DECISION DELEGATED TO DEVELOPMENT MANAGER

Application No: H17-0504-19 **Applicant:** Mr M & Mrs J Bennett
Proposal: Erection of dwelling - Outline approval H17-0242-17
Location: Off Stockhouse Lane Surfleet Spalding
Terminal Date: 9th September 2019

Scale: 1:100

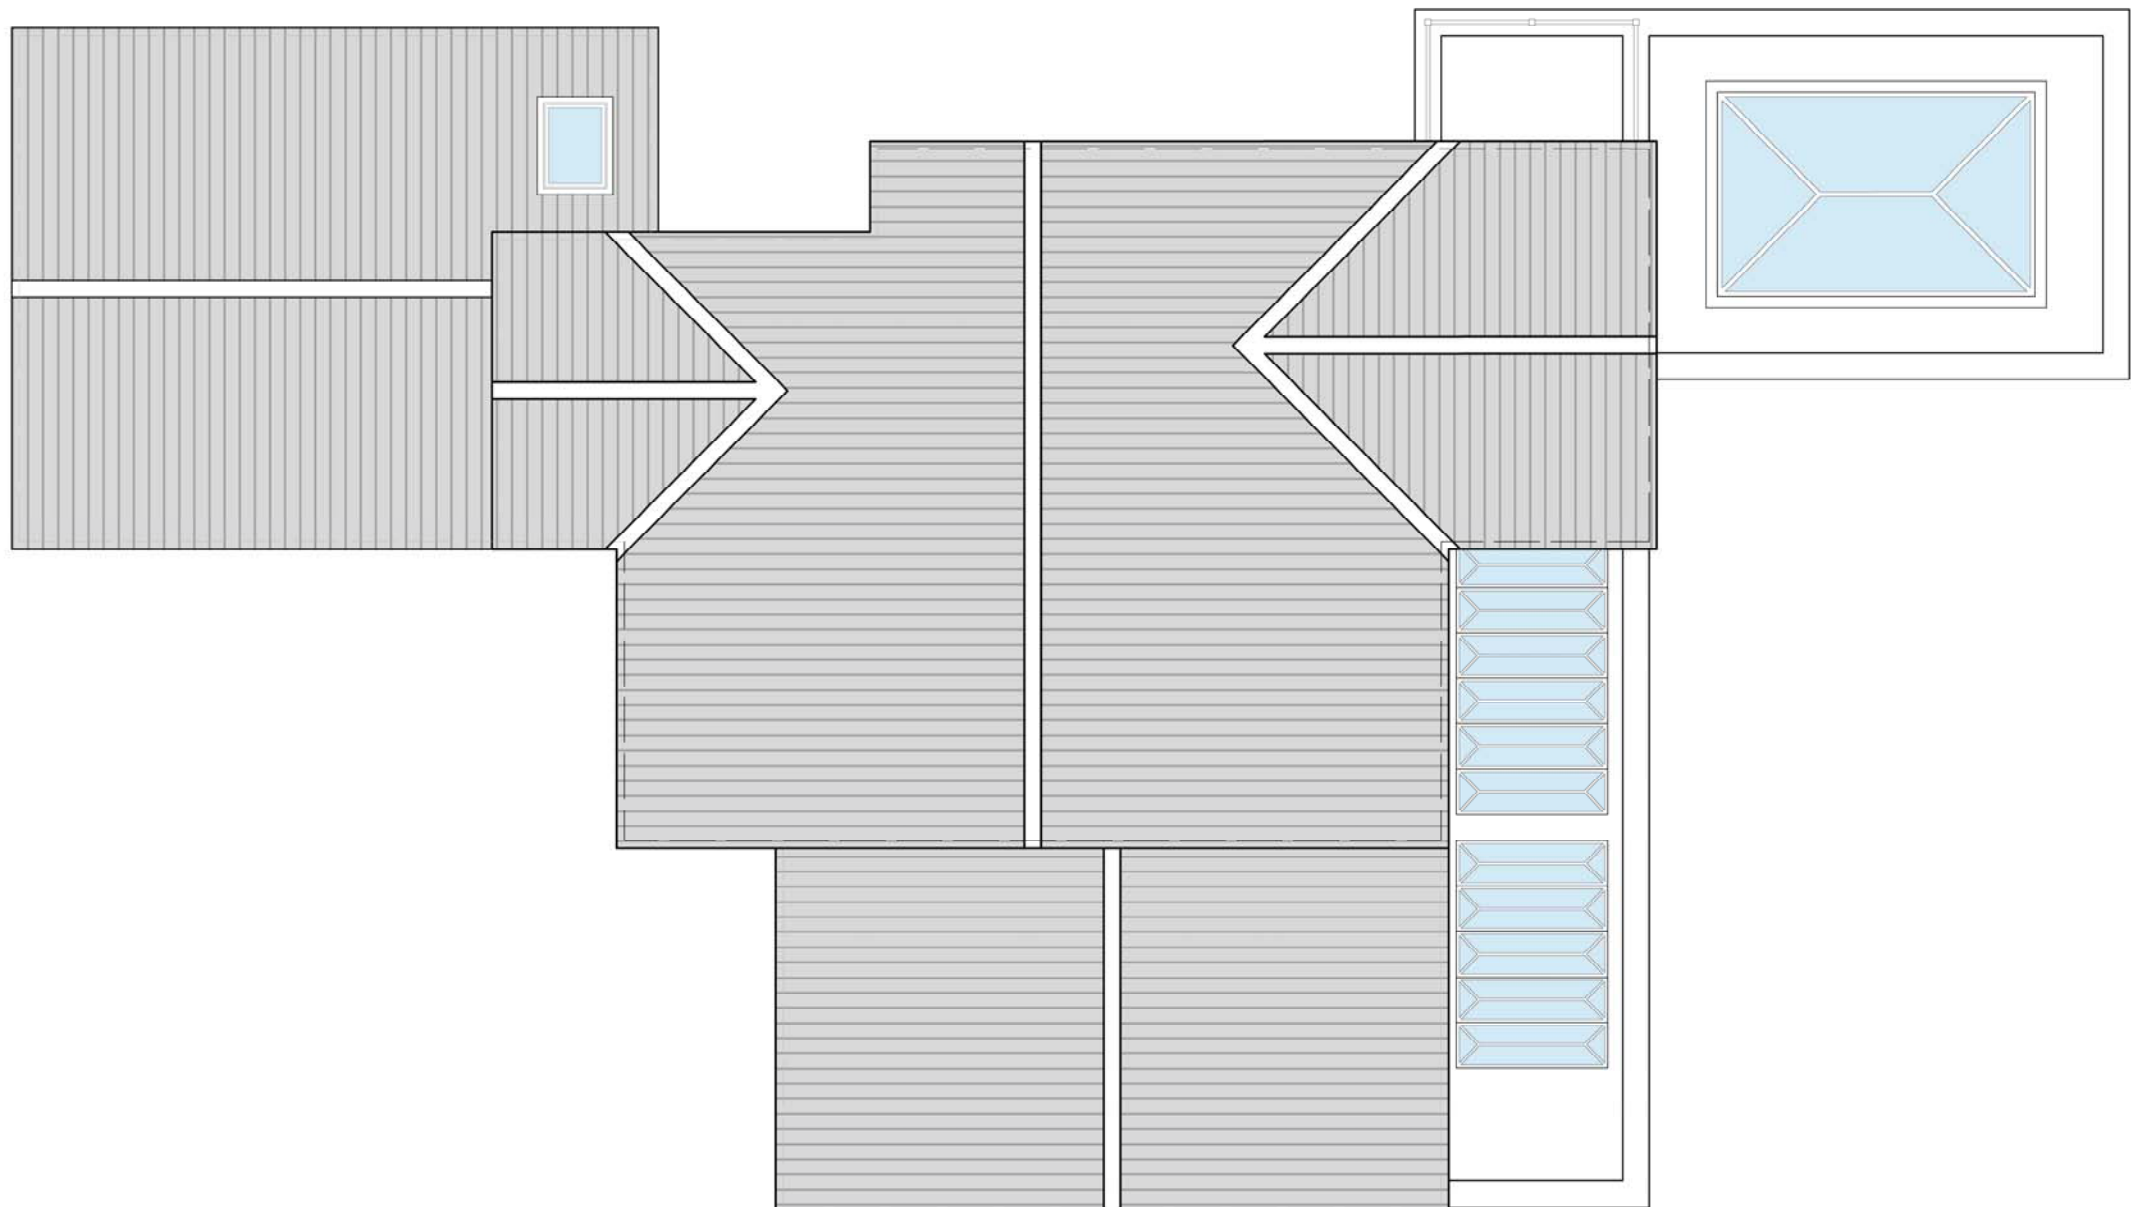
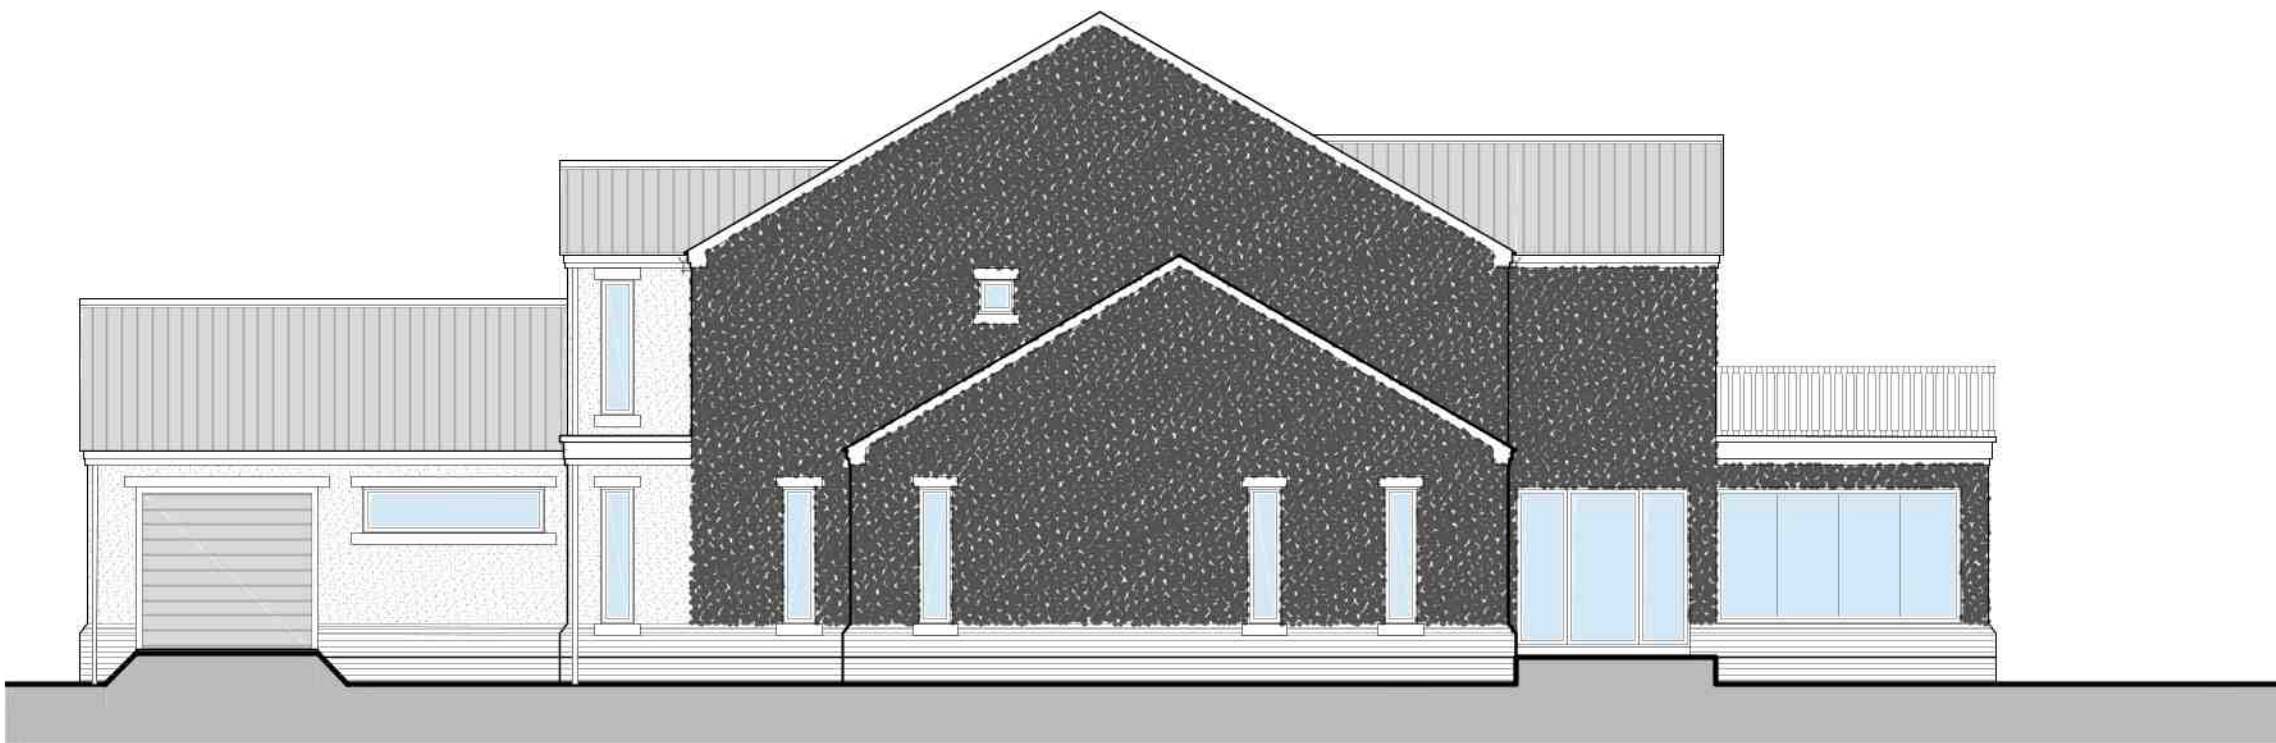
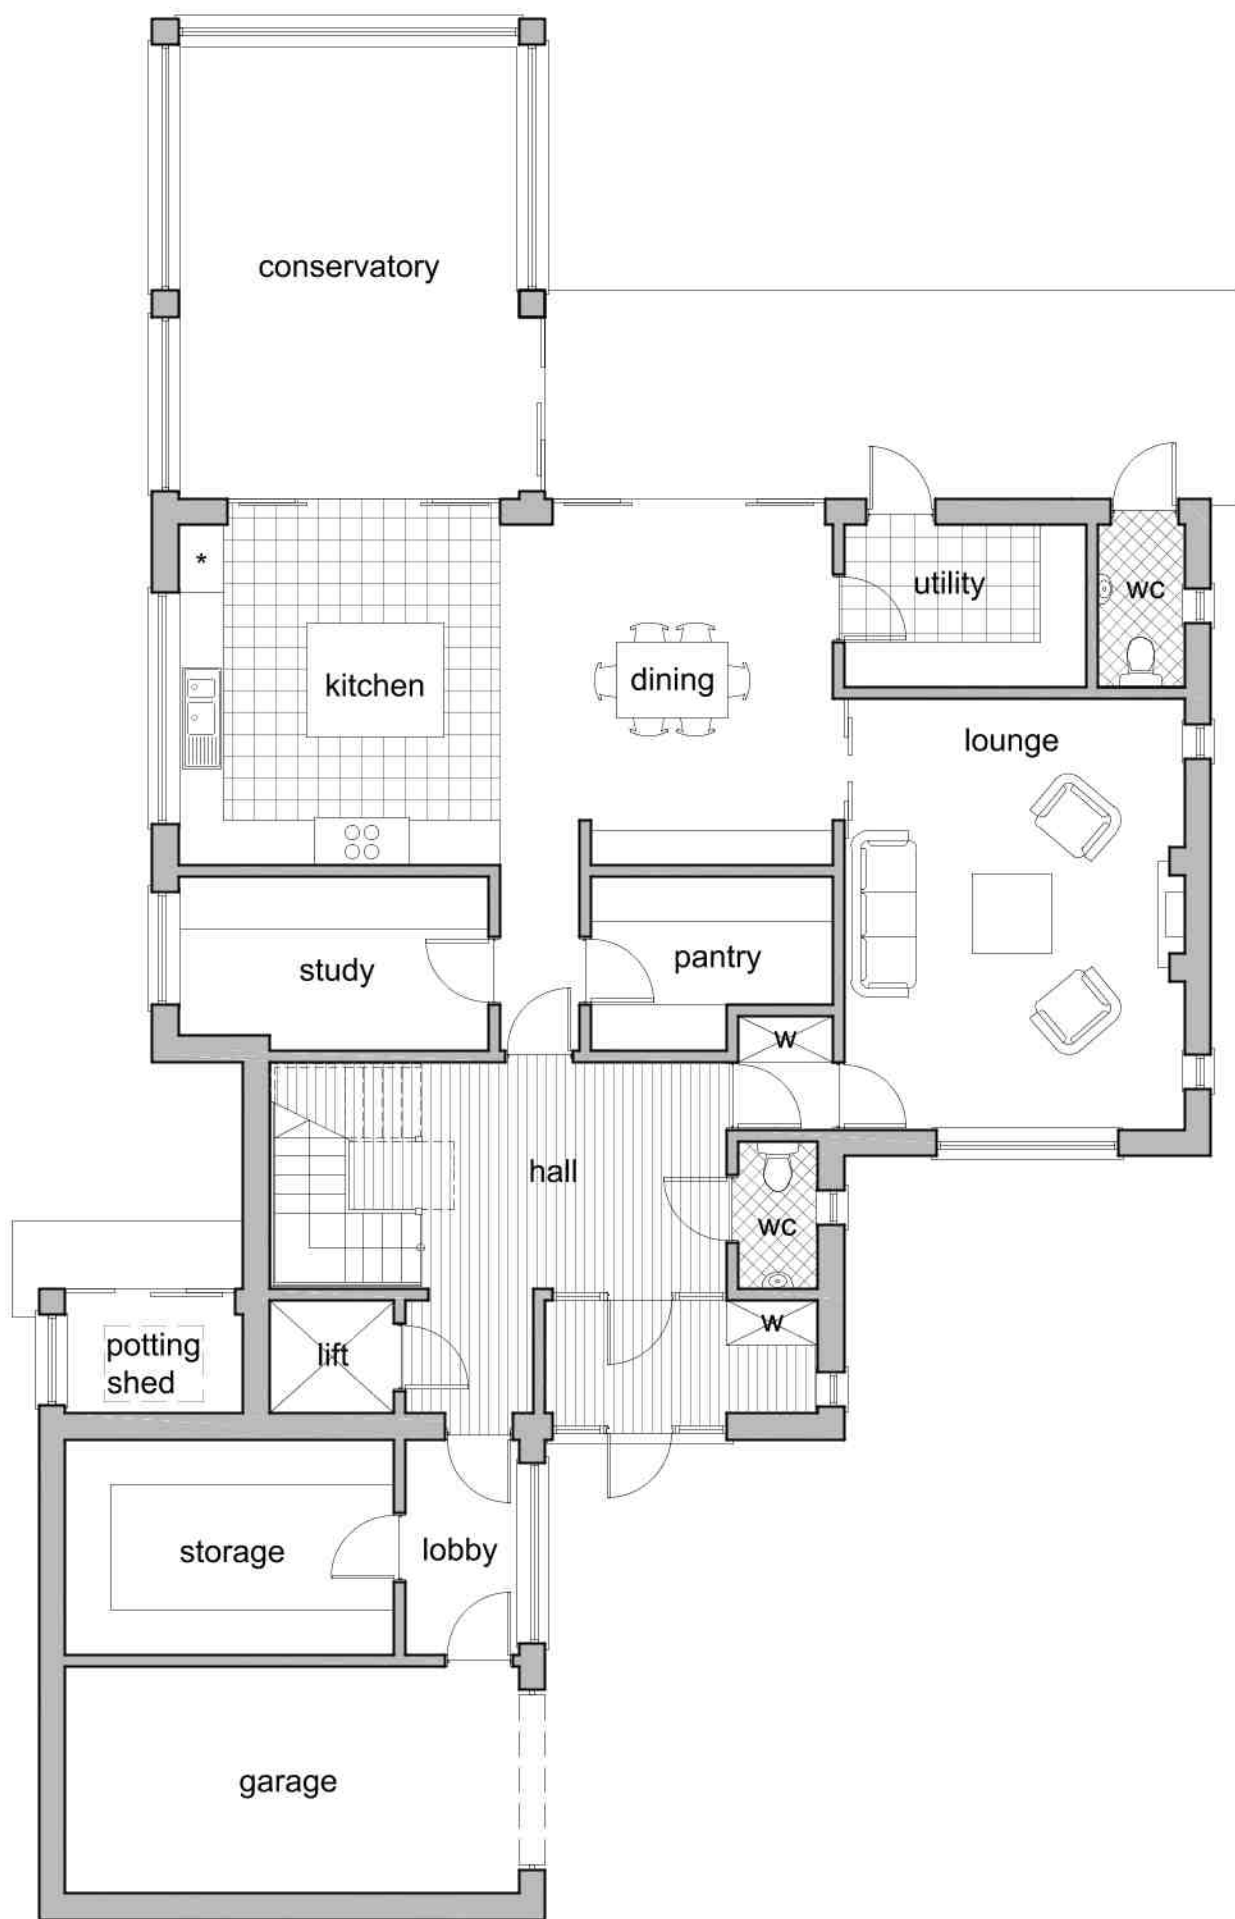
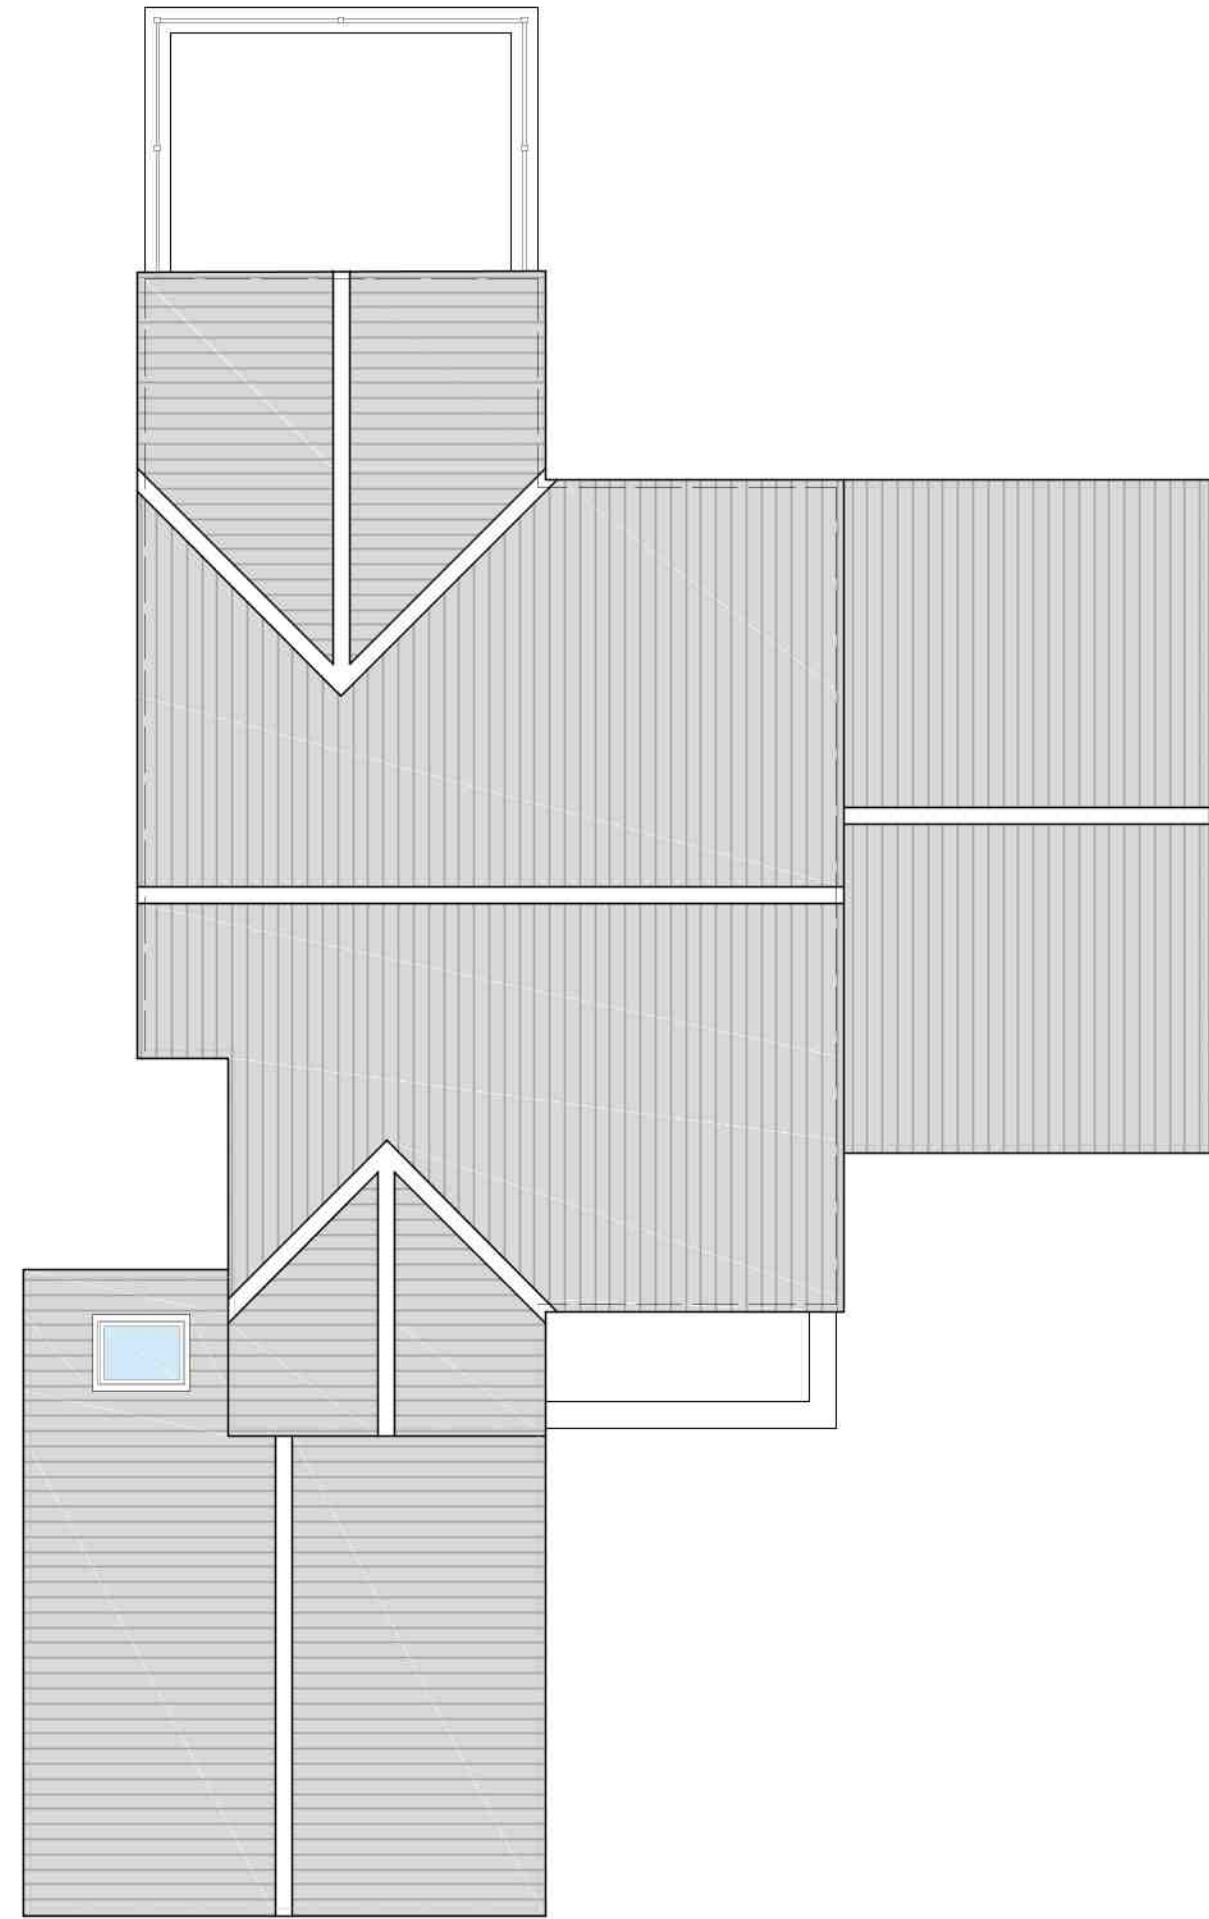
Following negotiations with the case officer the scheme has been amended and reduced in size from the original submission which was felt to be too large for the plot. Some of the massing of the property was in the single storey elements but it was felt to be too dominant and not at all in keeping with the plan submitted in support of the outline application.

The proposed dwelling even with amendment remains the antipathy of the Outline approval. The proposed house is a high solid block of integrated building which almost fills the plot and appears to have a footprint equal in size the adjacent homes put together. The design makes no attempt whatsoever to blend or reflect the overall nature of the surrounding properties which in this part of Surfleet are predominantly bungalows and cottages. It is totally out of keeping and will not enhance but dominate.

I strongly object to the proposed building/planning application because it in no way equates to the original approved outline planning application (H17-0242-17) which was for a chalet bungalow with detached garage and landscaping. The proposed house can in no possible way be described as a chalet bungalow and all the building is integral - its one big block of building with little landscaping disproportionate in size not only to the plot but to the adjacent bungalows and cottages in Stockhouse Lane, and in no way attempts to 'blend' or relate to the surrounding open countryside. In the original application the site was described as 'not visible' from the road, the house will not only be visible it will dominate. If this application is approved I find it makes a sham of the outline planning process.

The original submission plans for this Reserved Matters Application were for a dwelling that was considered excessive in size and not appropriate for the plot, nor did it reflect the (albeit indicative) Outline Planning Permission.

The design, size and scale including massing on the plot has all been revised by the Agent and the resultant scheme is more modest and more appropriate in its size and scale.

Following negotiations the Agent has re-designed a more appropriately sized dwelling which is now acceptable.

The design is acceptable and the amendments made by the Agent overcome the original concerns.
